Application number: 2026/91233	
What is the application for?:	Erection of detached dwelling
Address of the site or building:	50, Orchard Street, Savile Town, Dewsbury, WF12 9LH
Postcode:	WF12 9LH

Type of comment: An objection	
Do you wish your comments to be published on the website anonymously?	No
<p>I wish to formally object to the above planning application.</p> <p>My objection is based on material planning considerations, including the scale and intensity of the proposed development, its impact on neighbouring residential amenity, privacy, outlook, light, the character of the street scene, ecology, and the lack of sufficient supporting information to demonstrate that the proposal can be accommodated safely and appropriately on this constrained site.</p> <p>1. Overdevelopment of a constrained corner plot</p> <p>The application proposes a substantial detached dwelling on a relatively constrained and irregular corner plot at the junction of Orchard Street and Cross Street. The proposed dwelling is not a modest infill development. It is a large, multi-level family dwelling with accommodation over lower ground, ground, first and second-floor levels.</p> <p>In my view, the scale, he

Section A-A / Cross Street Elevation As Proposed
Scale 1:200
0m 5m 10m

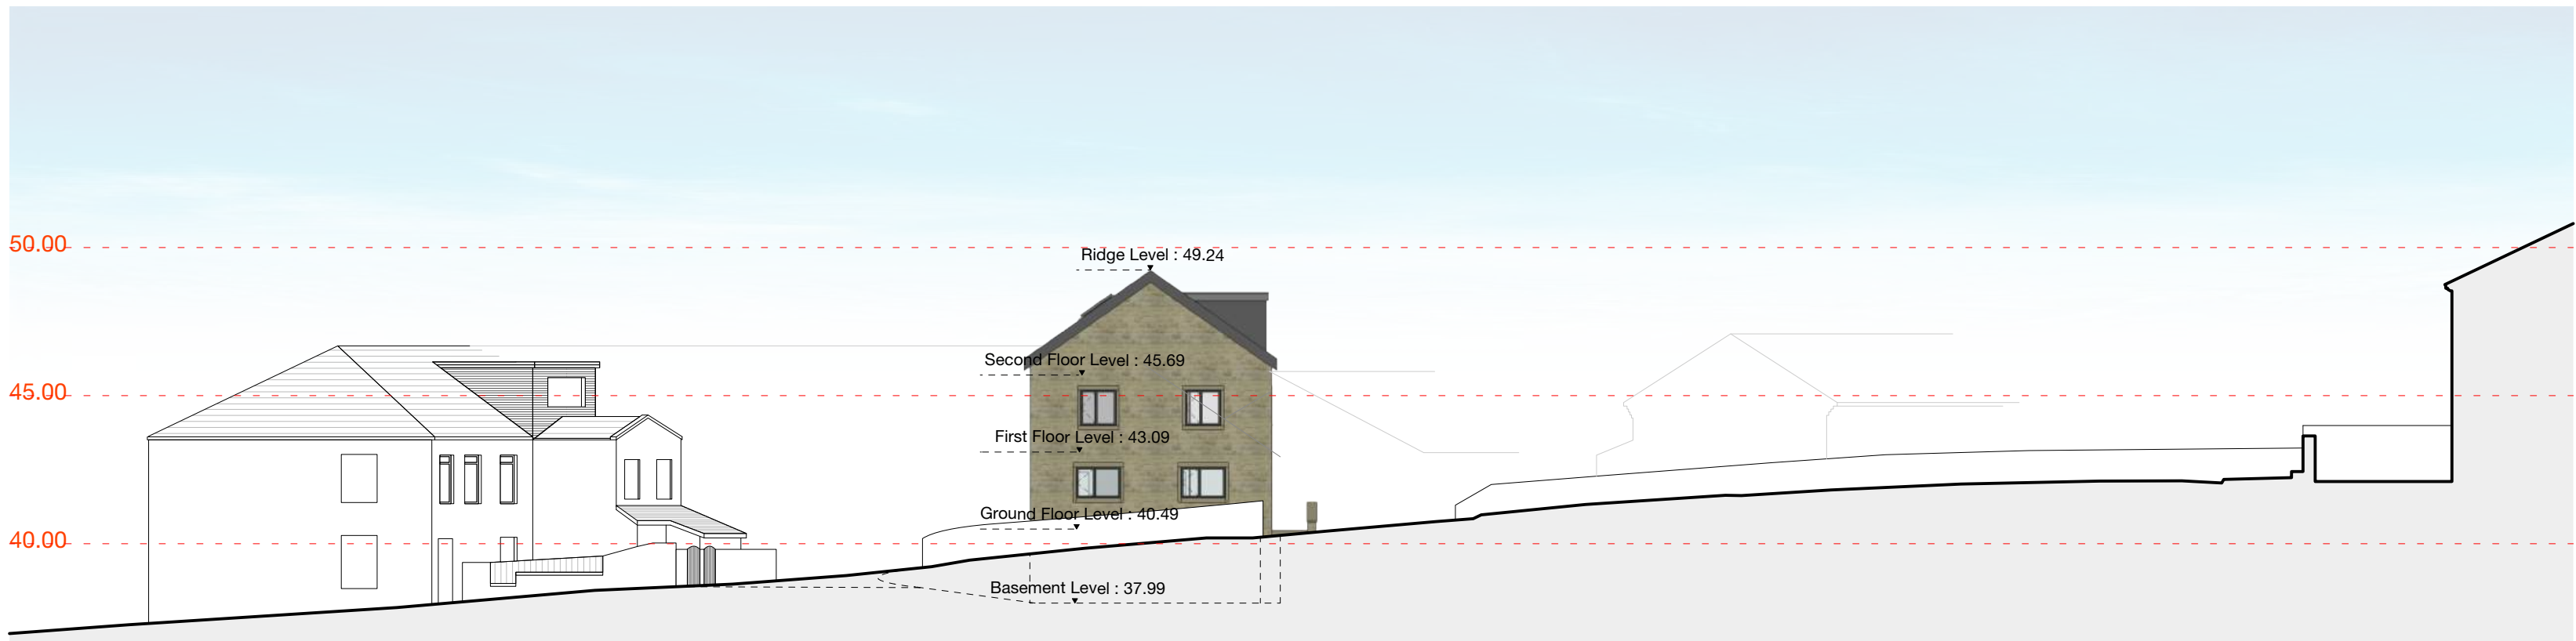
The proposed dwelling would occupy a prominent corner position at Orchard Street and Cross Street. Because of this, the development would be highly visible within the street scene.

The current open corner provides visual relief in an otherwise built-up residential area. The proposed dwelling would remove that openness and replace it with a large, dominant structure. The result would be a more cramped and enclosed appearance, which would be harmful to the character and appearance of the immediate area.

The proposal does not appear to respond sufficiently to the existing pattern of development, spacing, scale, or the character of surrounding properties. A development of this size on this plot would appear forced rather than naturally integrated into the street scene.

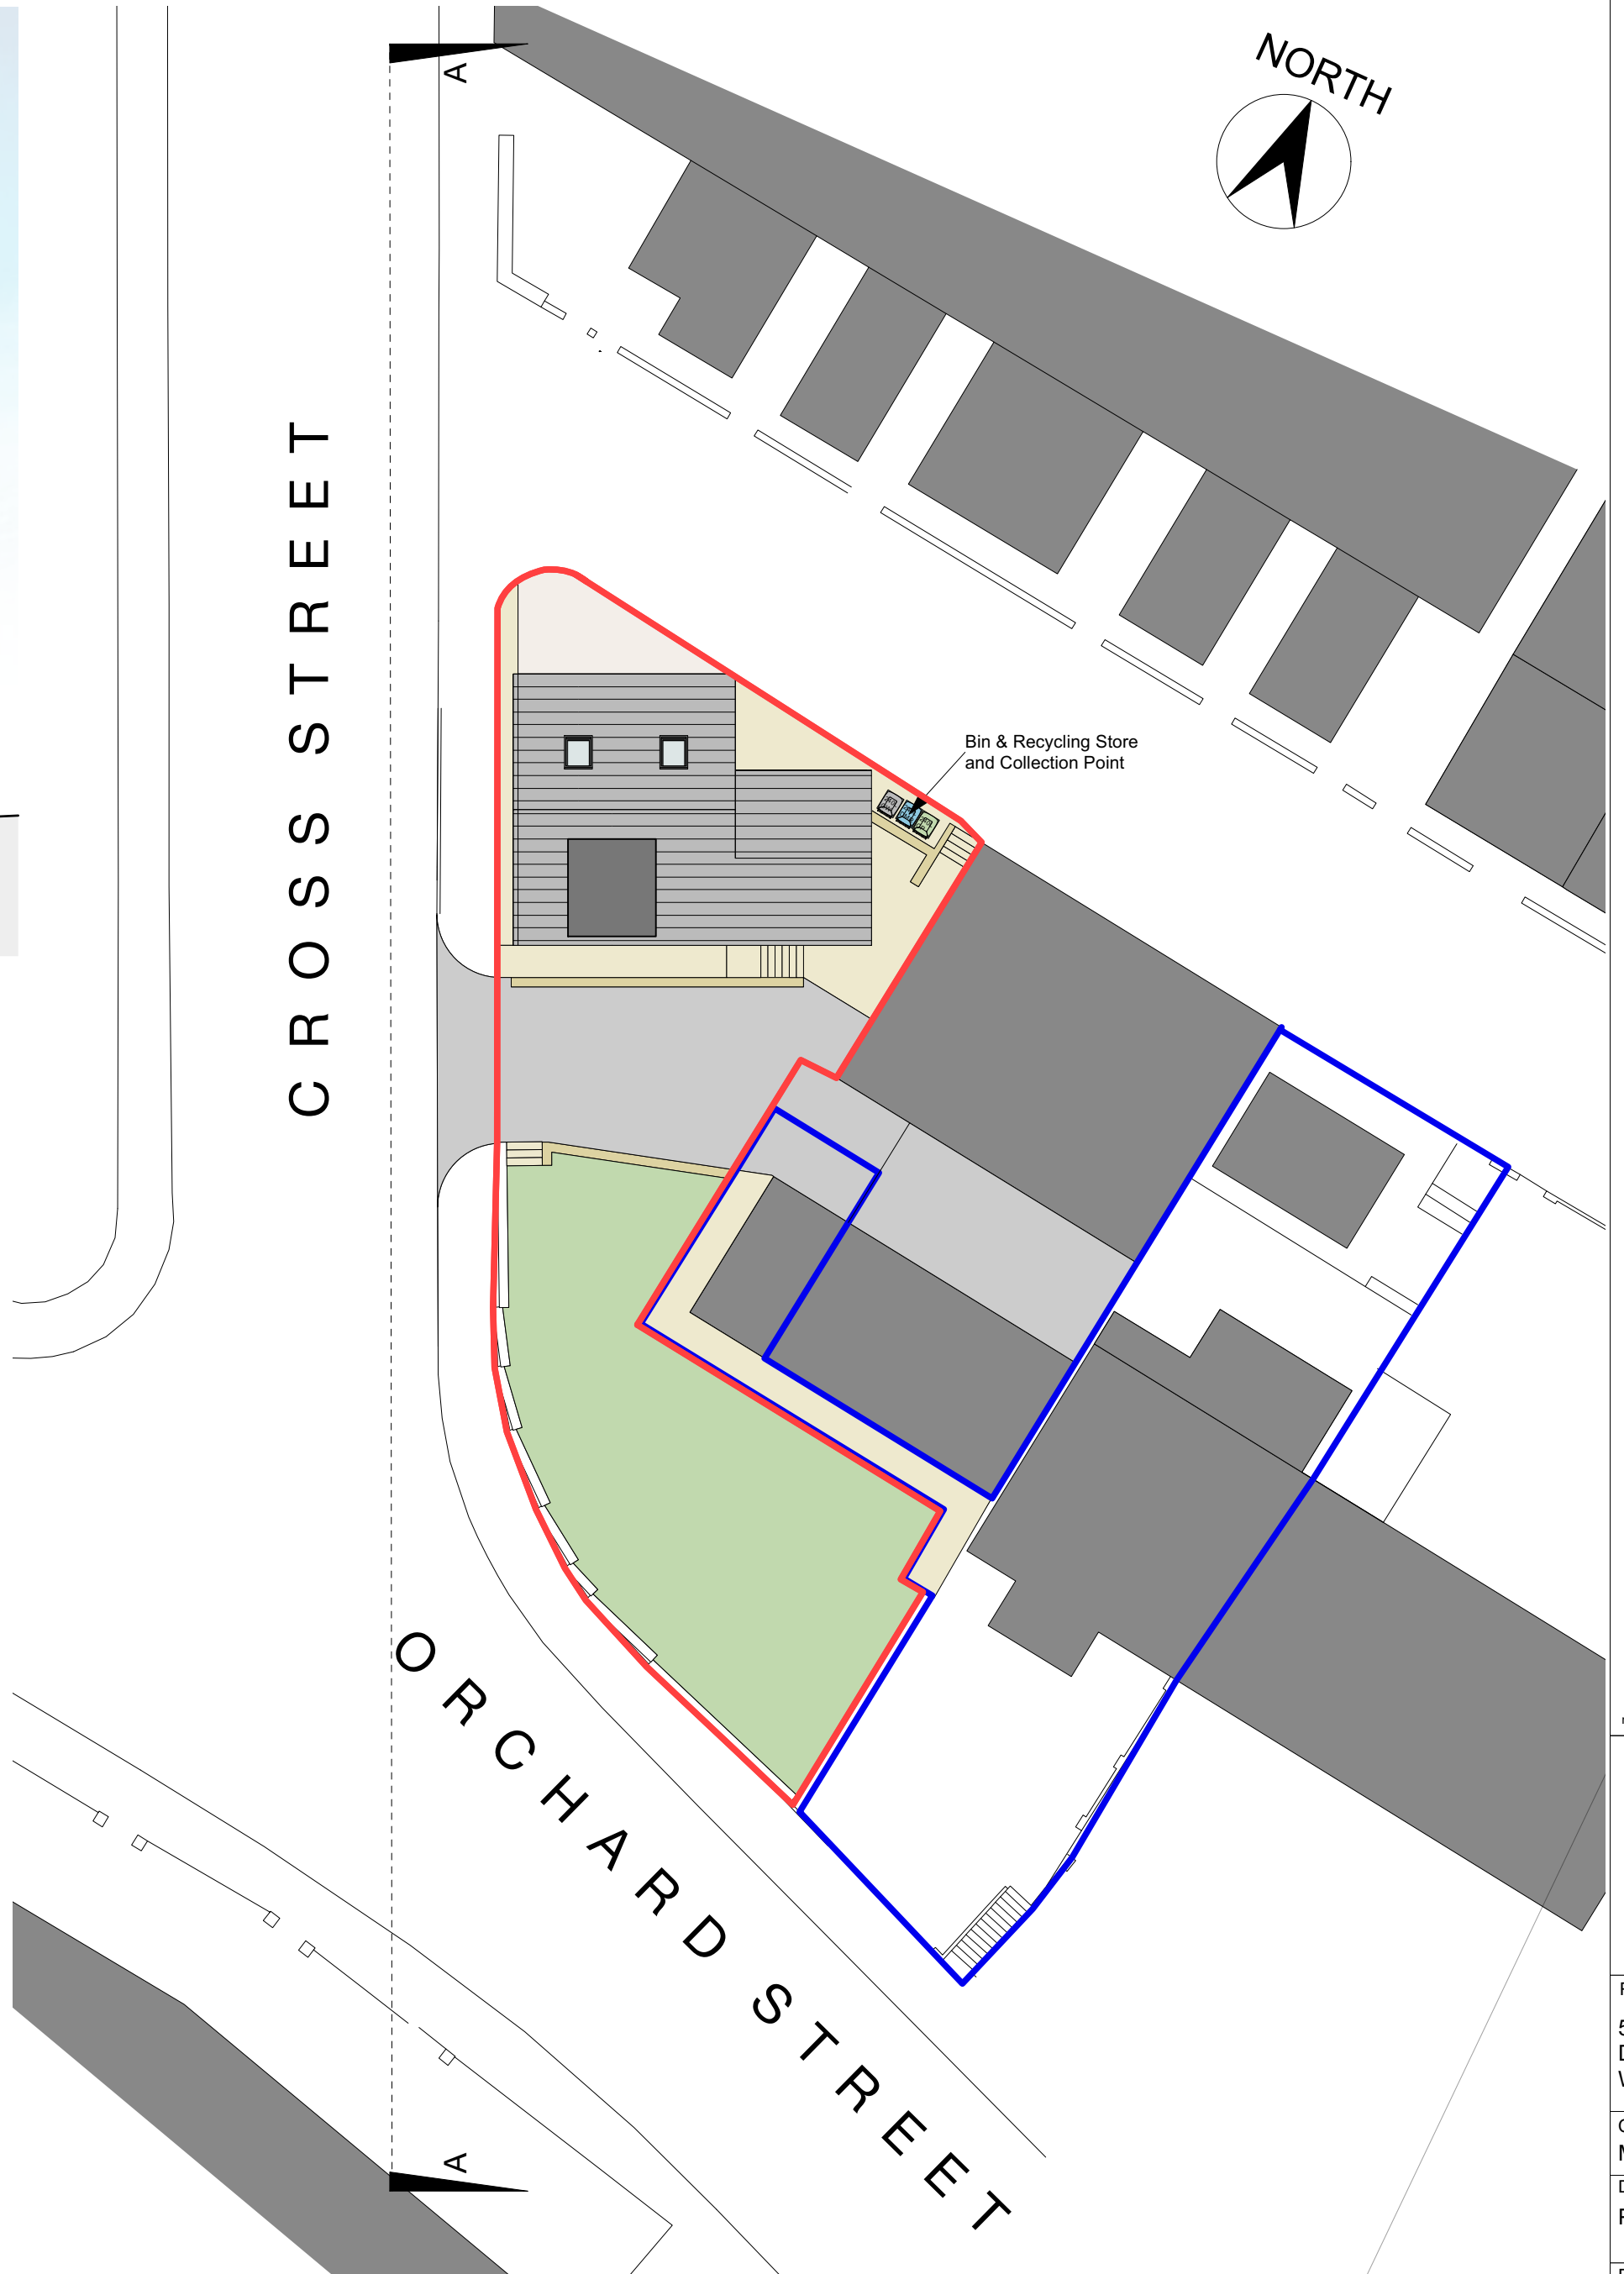
The proposed dwelling includes upper-floor windows serving habitable rooms. Given the position of the plot and its relationship with nearby homes, there is a real risk of direct overlooking into neighbouring properties.

The issue is not simply that a new house would be visible. The concern is that the proposed upper-floor accommodation would materially change the existing privacy relationship between homes. Existing residents currently benefit from a more open outlook across the site. The proposed dwelling would create new elevated viewpoints from first and second-floor windows, increasing the risk of overlooking into bedrooms, living areas and private domestic spaces.

The Council's guidance refers to recommended separation distances between habitable room windows and the need to avoid harmful overlooking. The application does not clearly demonstrate that these standards are met, nor does it provide adequate mitigation such as repositioned windows, obscure glazing where appropriate, or a revised layout to reduce overlooking.
